Rezoning Transportation Analysis

Petition Number: 2023-046

Revision Log:

Date	Description
08-25-23	First Review (NK)
09-20-23	Second Review (NK)
11-22-23	Third Review (TP)
12-20-23	Fourth Review (NK)
1-24-24	Fifth Review (NK)
2-21-24	Sixth Review (DR)

LEGEND

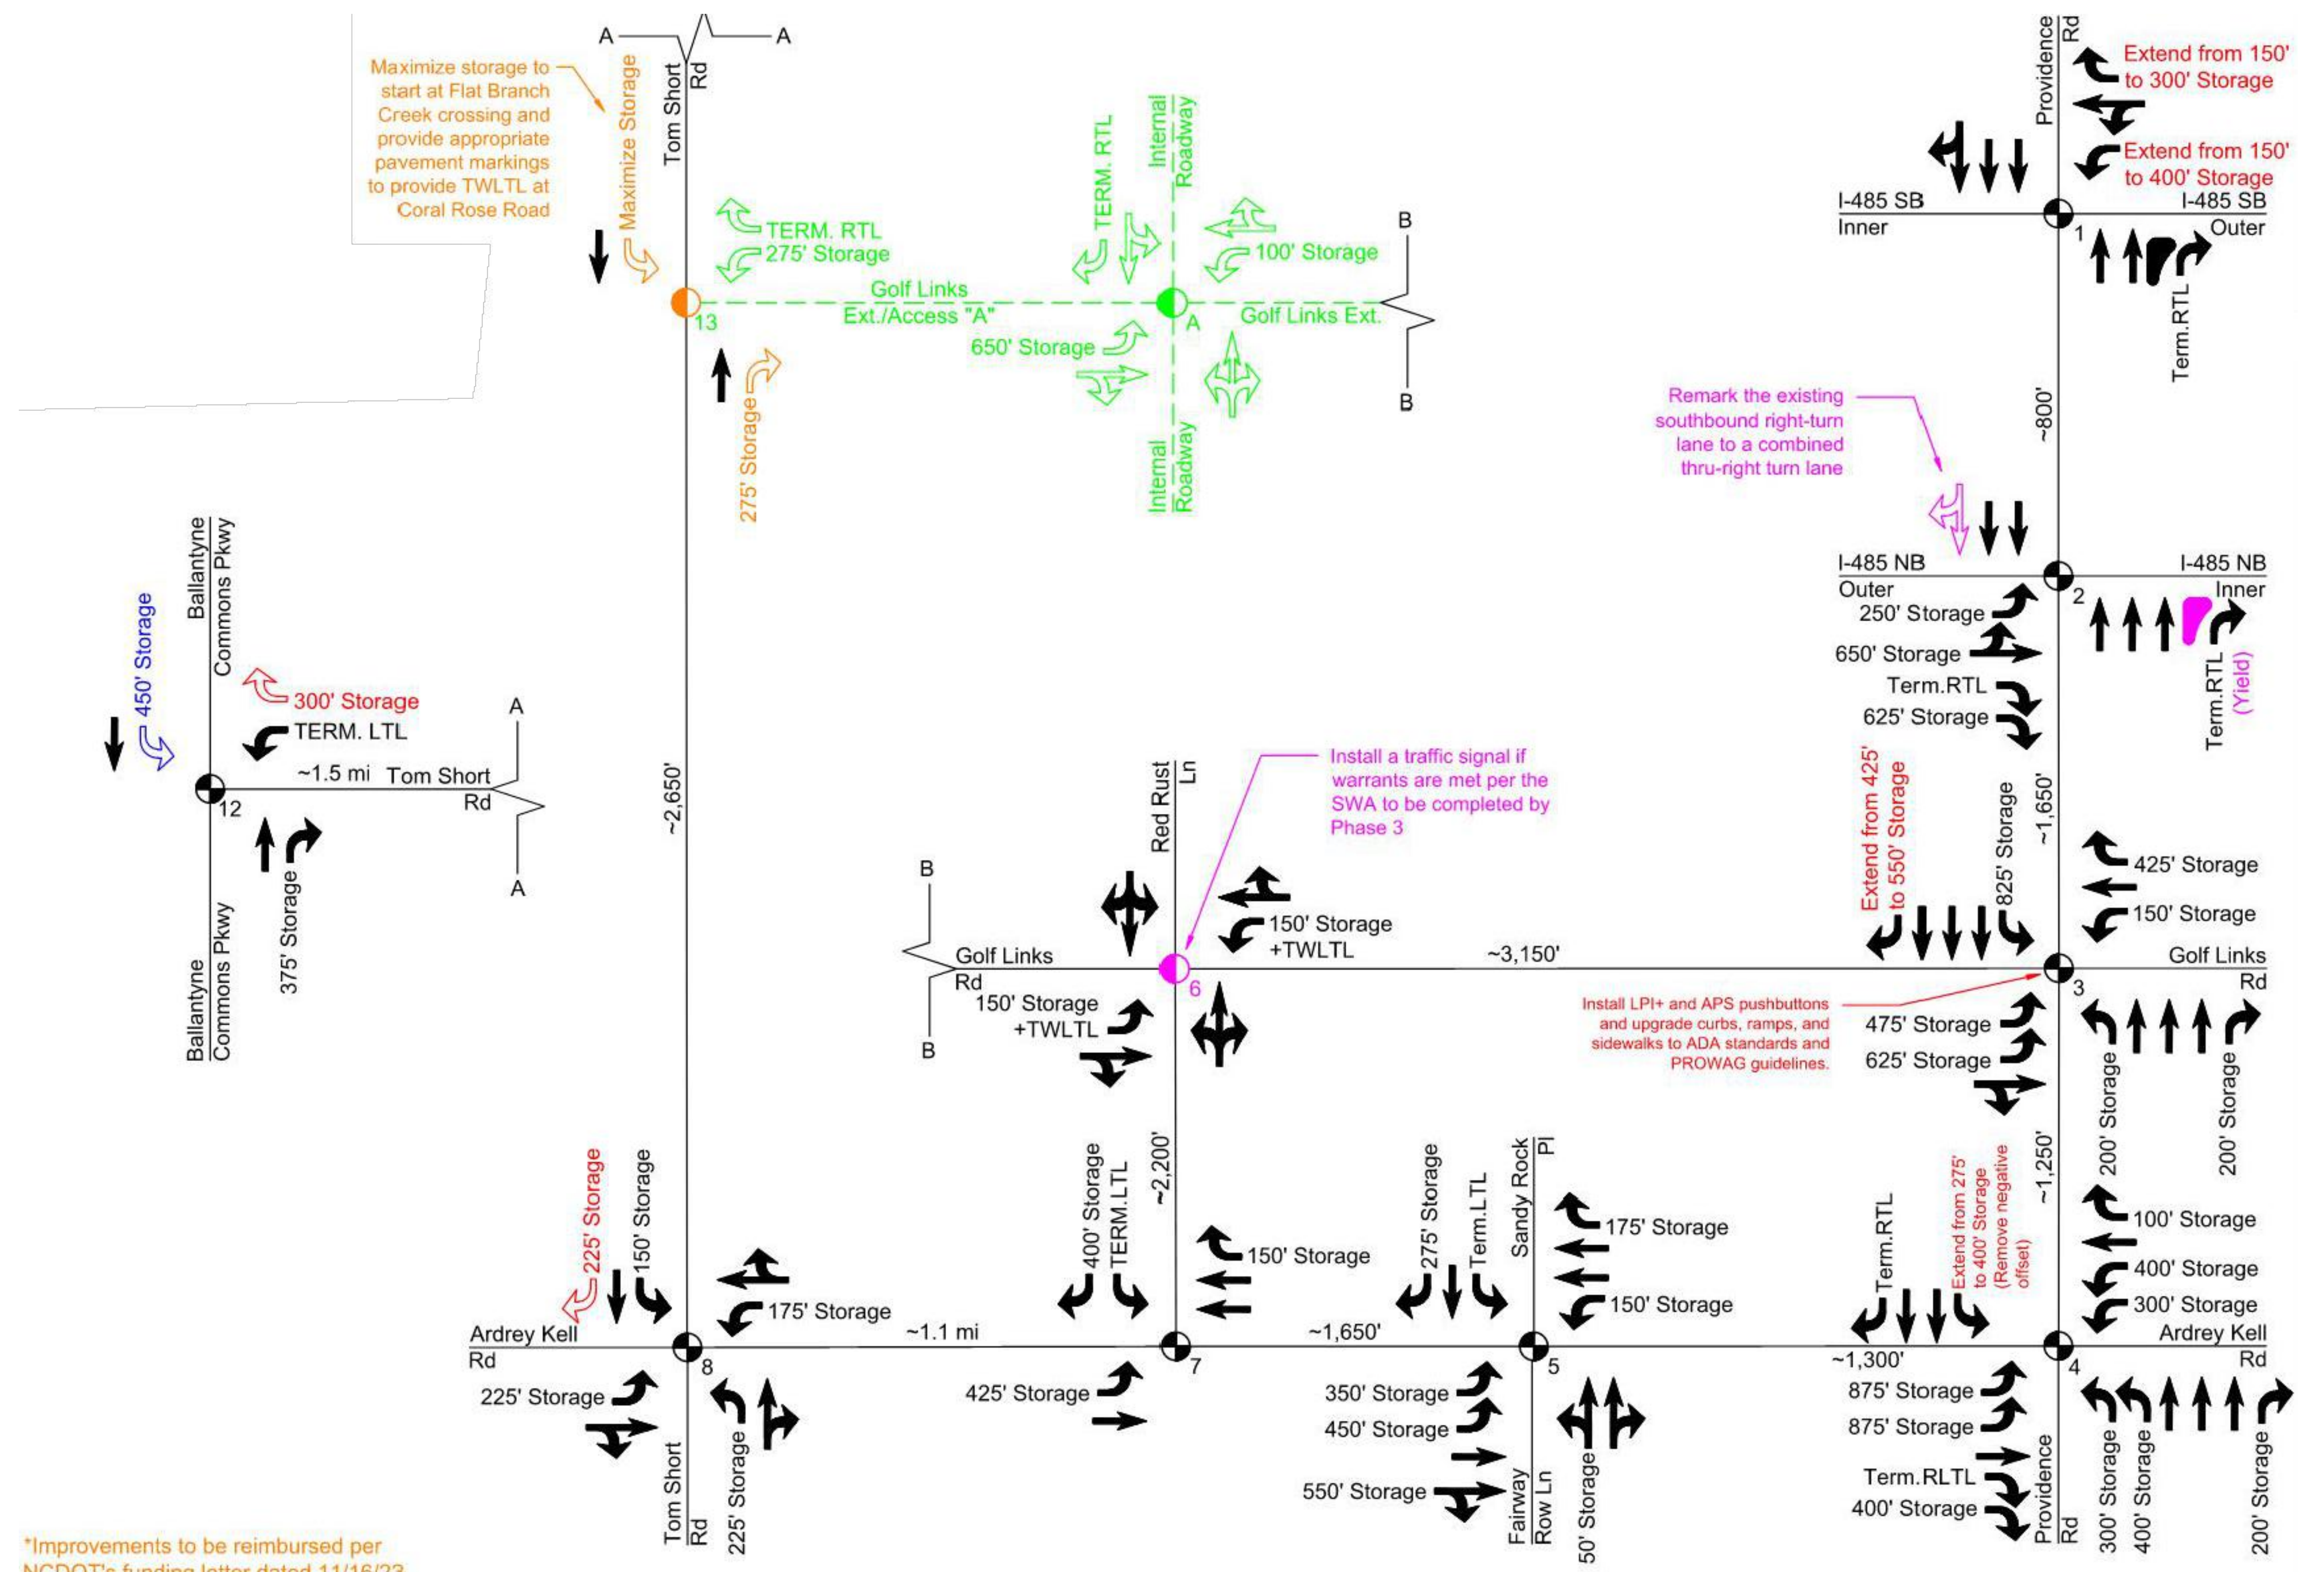
REMOVE HIGHLIGHTED BELOW:

1. I-485 SOUTHBOUND RAMP & PROVIDENCE ROAD (SIGNALIZED)

- EXTEND THE EXISTING WESTBOUND LEFT TURN LANE FROM 150 TO 400 FEET OF STORAGE.
- EXTEND THE EXISTING WESTBOUND RIGHT TURN LANE FROM 150 TO 300 FEET OF STORAGE.

REMOVE HIGHLIGHTED BELOW:

10. TOM SHORT ROAD & POLO RIDGE ELEMENTARY SCHOOL DRIVEWAY-OUT (UNSIGNALIZED)

- **INSTALL A TRAFFIC SIGNAL.**

3. ~~Revise site plan and conditional note(s) to commit to dedicate 46' right of way from the road centerline. The site plan shall label and dimension the right of way from the road centerline.~~
4. **New Comment 2/21/24:** Update highlighted improvement to match wording from TIS that was approved on 2/1/2024. Approved TIS says that "Signalization to be explored in permitting with coordination from CDOT's E&O division.

PROPOSED STREET DIMENSIONS

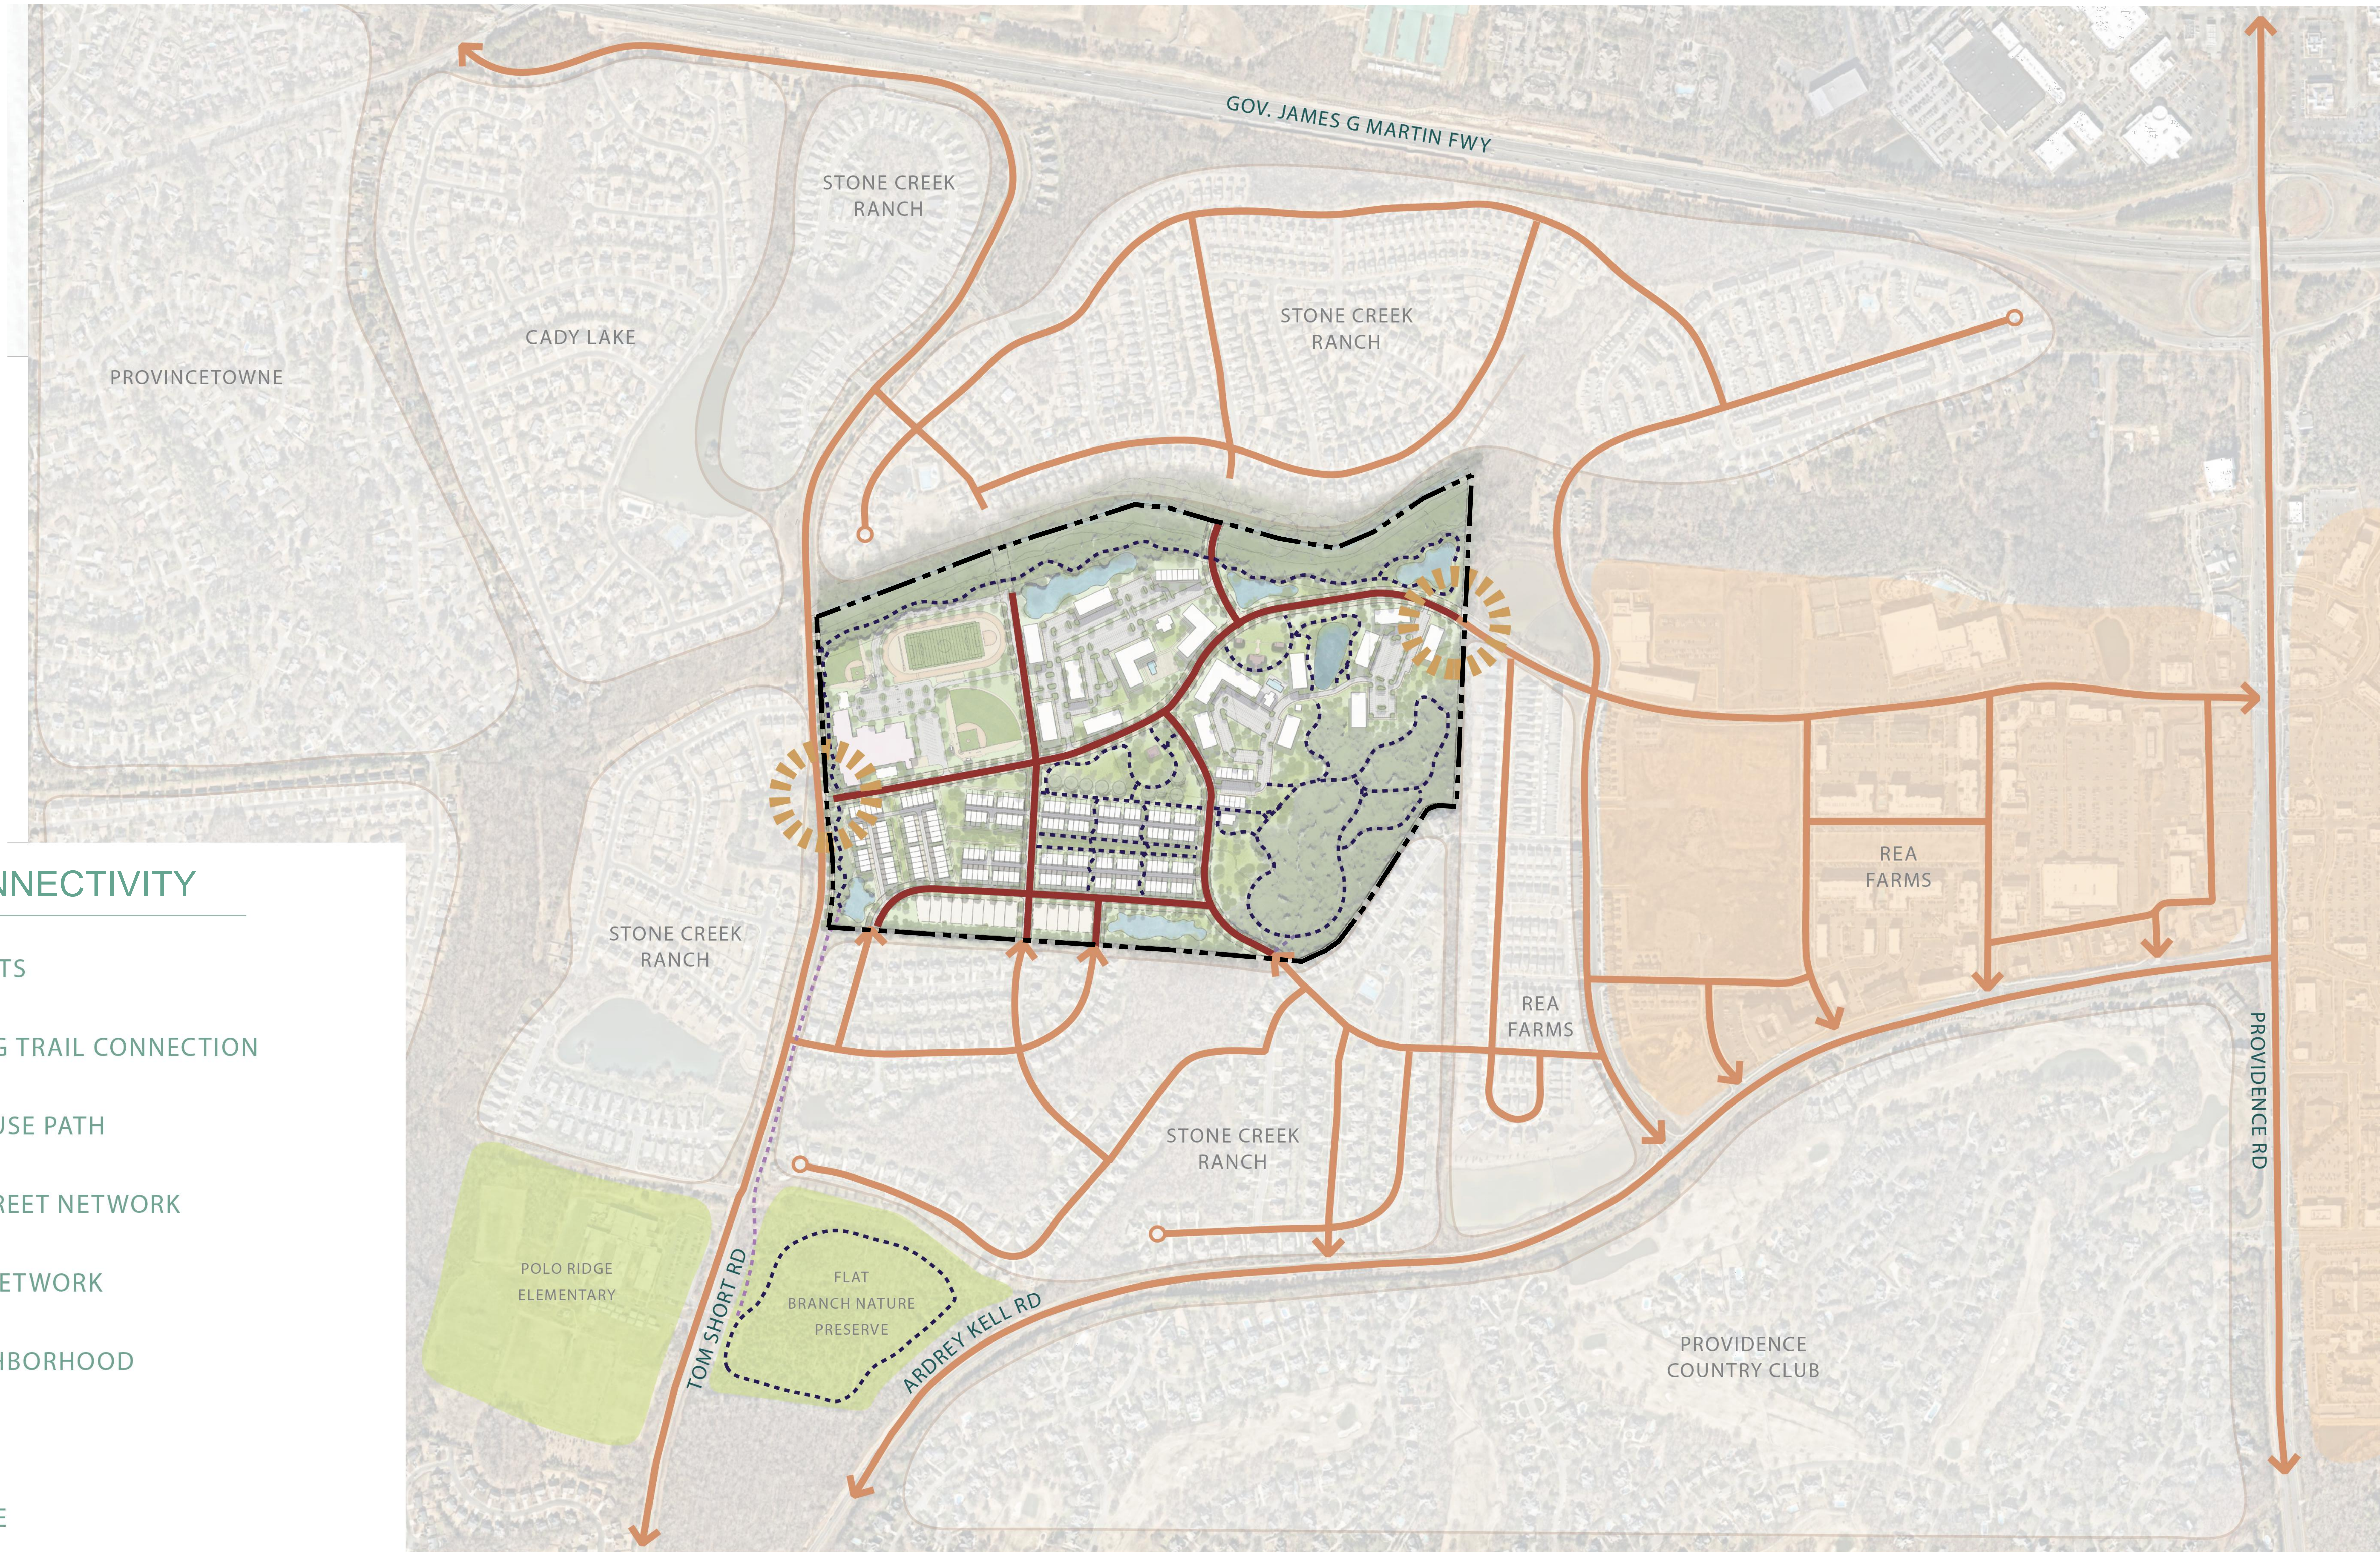
9. **Outstanding Issue 8/24/23:** Remove this intersection, and ensure all future horizontal curves meet the minimum CDOT standard of 150' radius.

10. **Outstanding Issue 8/24/23:** Align internal public roads to remove offset intersections.
